EARLY GRADING AND EROSION CONTROL PLANS SPRINGS AT WATERVIEW

EL PASO COUNTY, STATE OF COLORADO

PROJECT SPRINGS AT WATERVIEW

# EARLY GRADING AND EROSION CONTROL PLANS

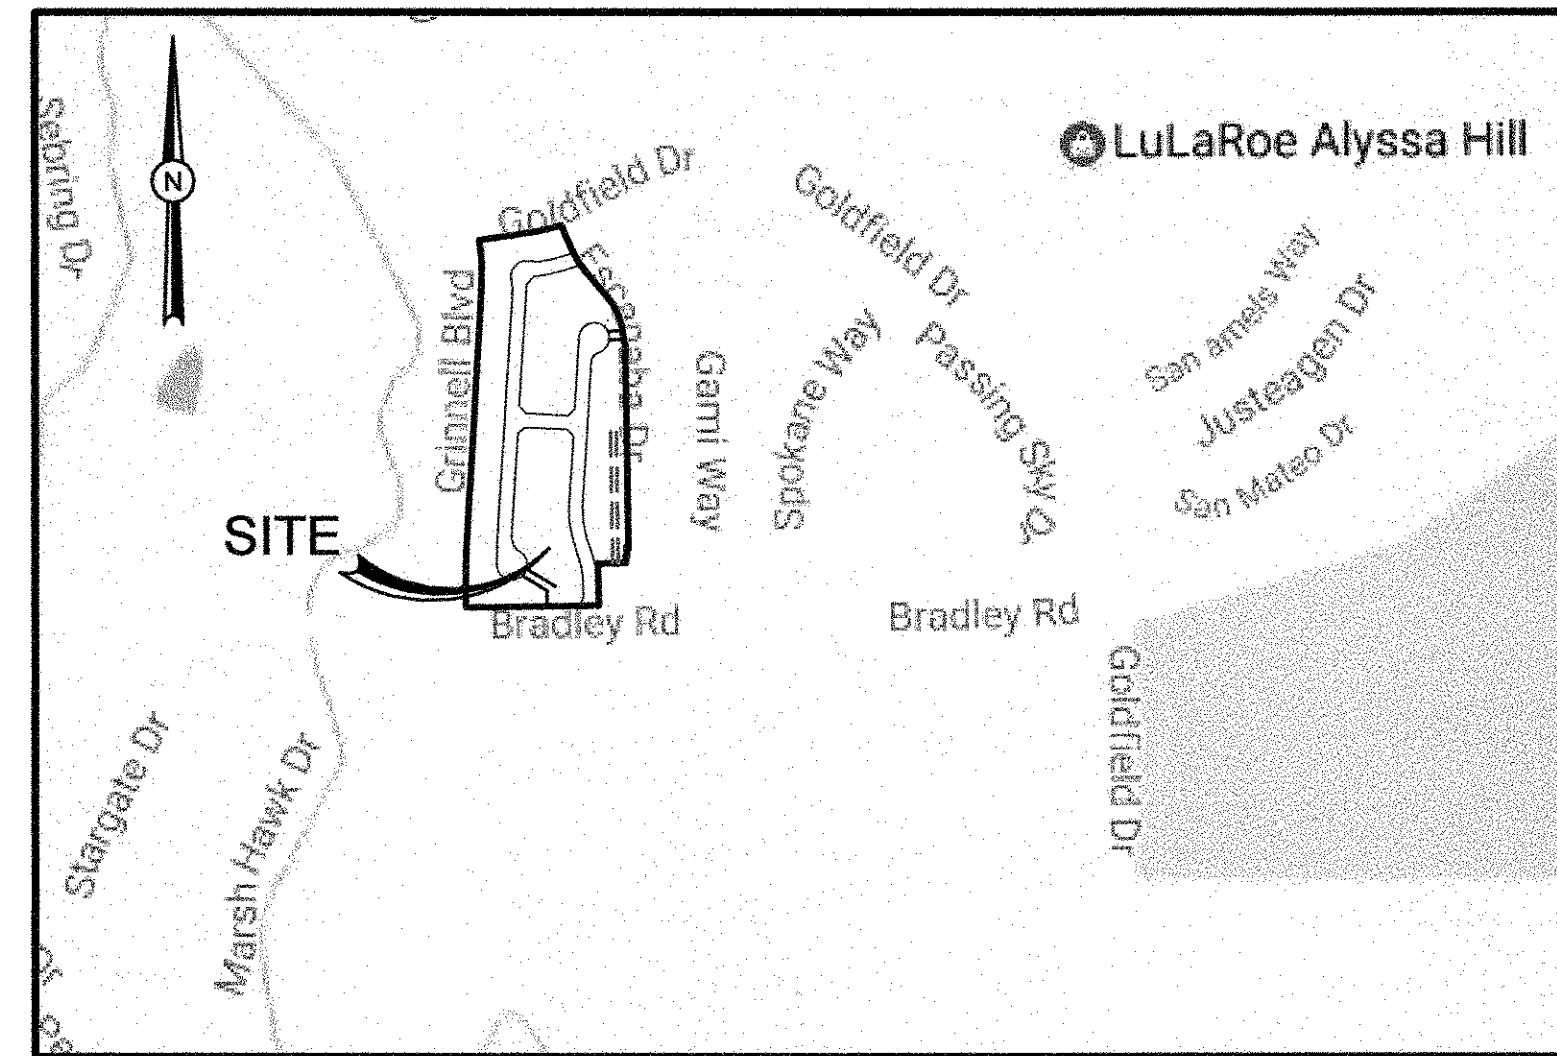
Revise header to "El Paso County"

PROJECT SPRINGS AT WATERVIEW  
 SHEET TITLE GRADING & EROSION CONTROL PLAN  
 FROM \_\_\_\_\_ TO \_\_\_\_\_  
 JOB NO. 0102.1 SHEET 4 OF 6

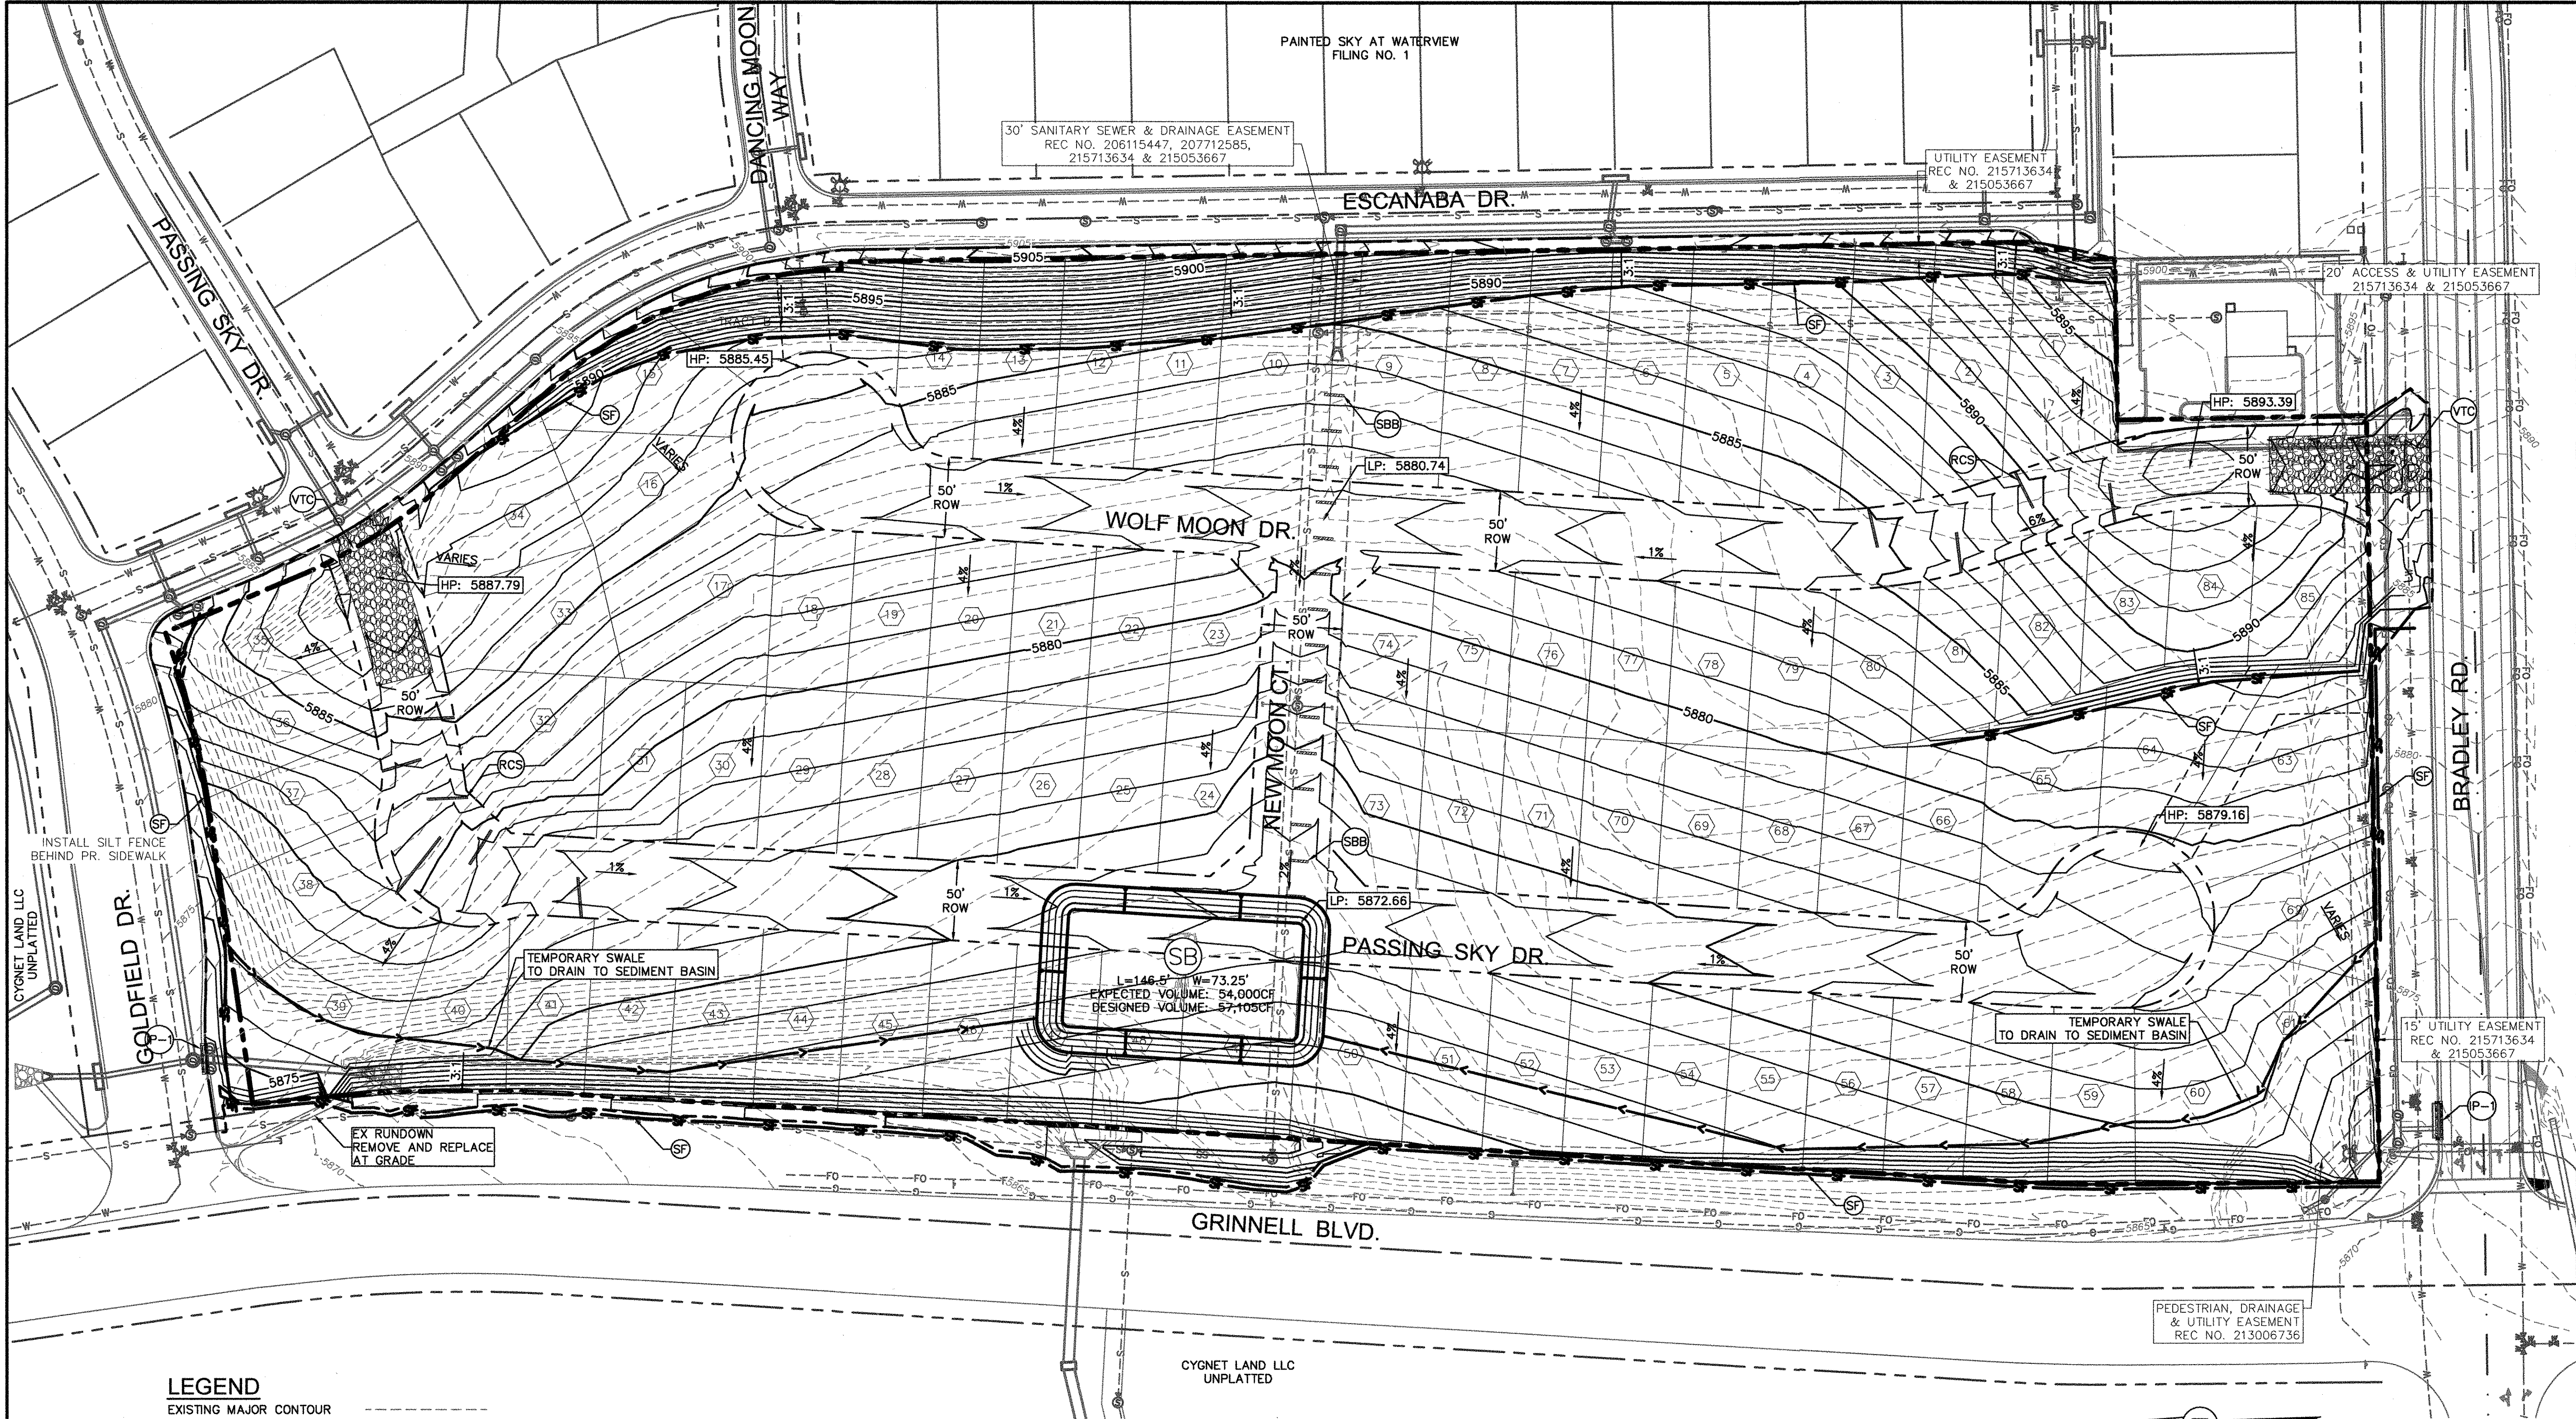
1. Show the actual design contours. Identify the minimum required volume

Identify RCS along these road segments

Add Inlet Protection

Add Inlet Protection
